From: Martyn White
Sent: 20 August 2015 15:01
To: Planning.Responses
Cc: Anita Gardner
Subject: A/76/15/PL

**ADC Planning Consultation
Response from the Conservation Officer**

Application Number	A/76/15/PL
Address	Angmering Manor High Street Angmering BN16 4AG
Description	Single storey rear extension & re-modelling of front car park area to increase number of spaces from 25 to 32
Case Officer	Mrs. A Gardner

Title
ADDITIONAL GARDEN BEDROOMS
ELEVATIONS

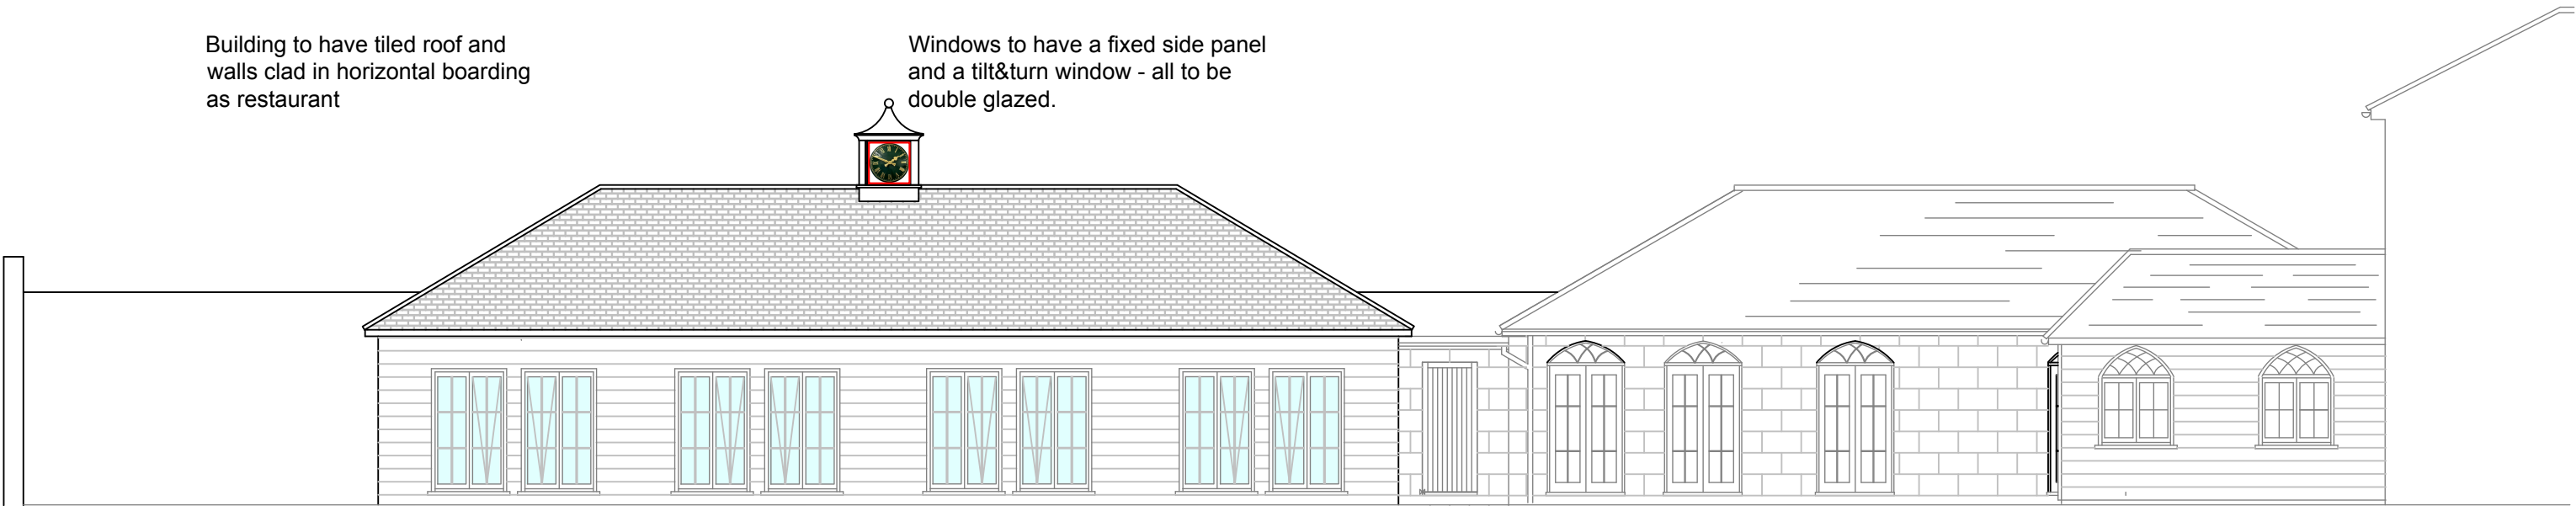
- Door/window details including sections
- Material samples for roof, elevations and guttering
- Detailed drawing of clock tower (please note that this is not shown on the south elevation)
- Planting scheme for the front parking area.

Tree Protection Plan

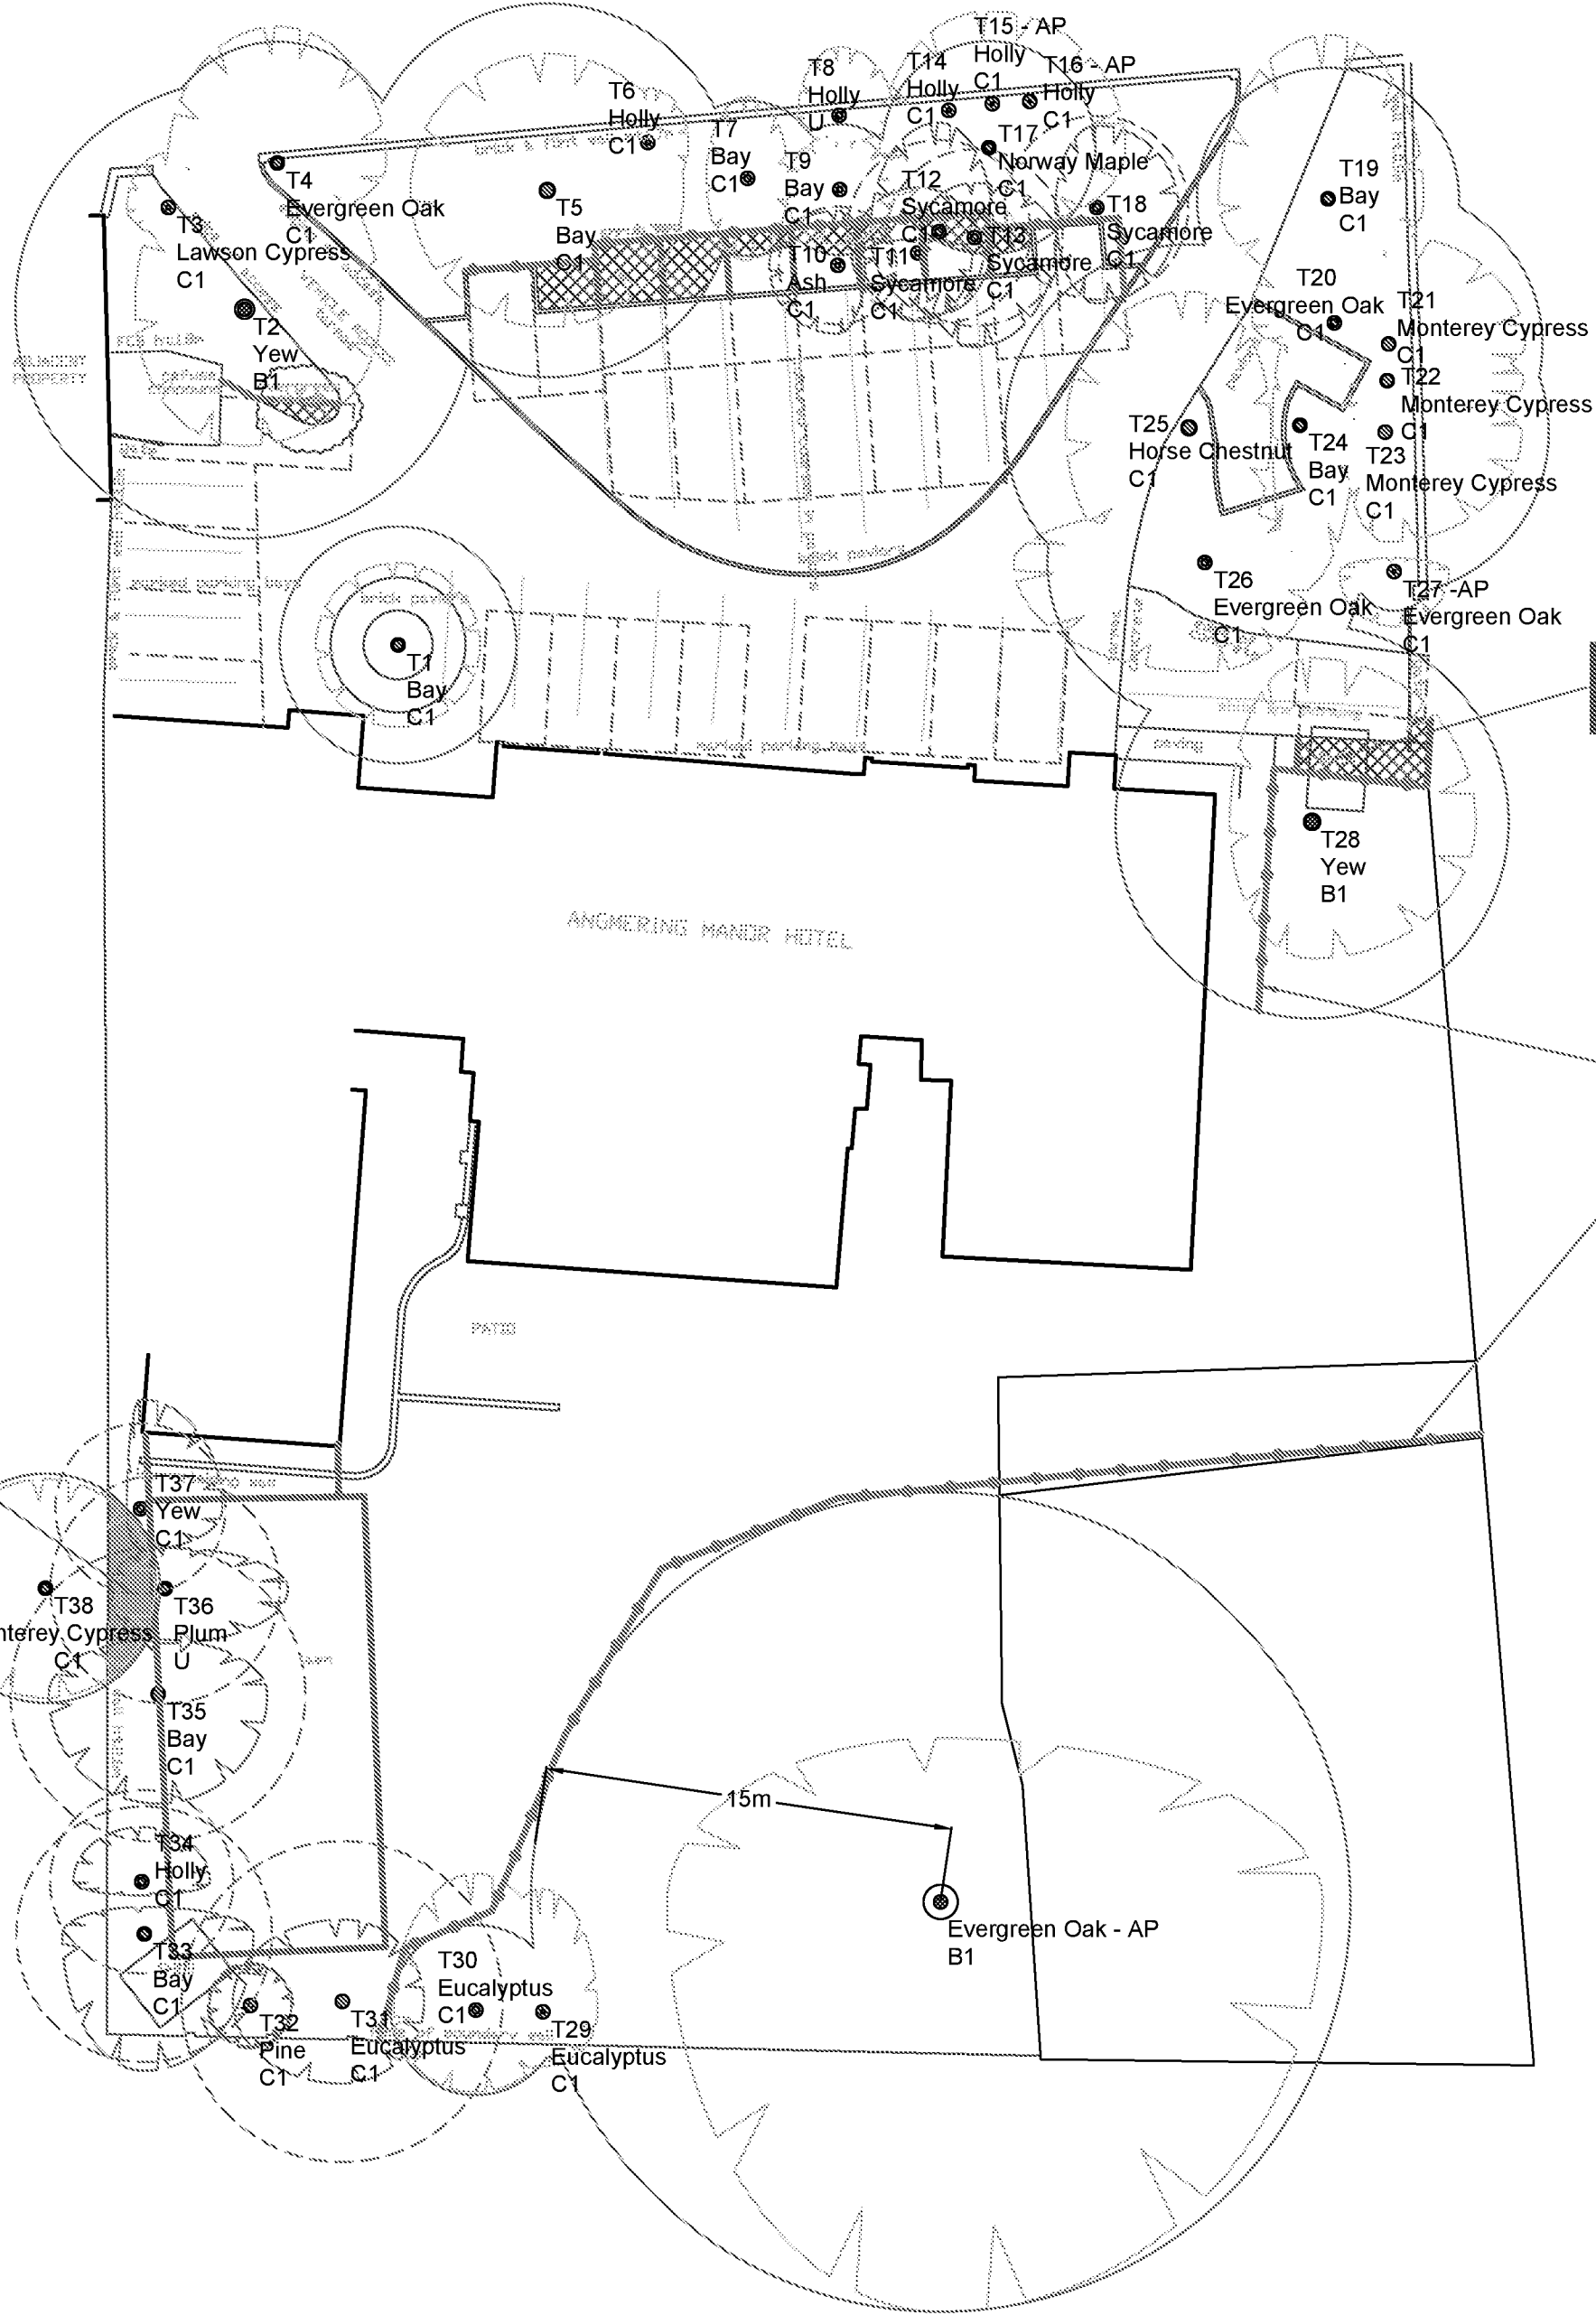
With regard to the parking proposals, there is some concern that the loss of the vegetation could result in the car park being exposed to the street. Such a result could not be supported. As a result, it is requested that suitable arrangements be made to ensure that appropriate screening is provided as part of any scheme. Consequently, you may wish to request a planting scheme be provided to mitigate any impacts.
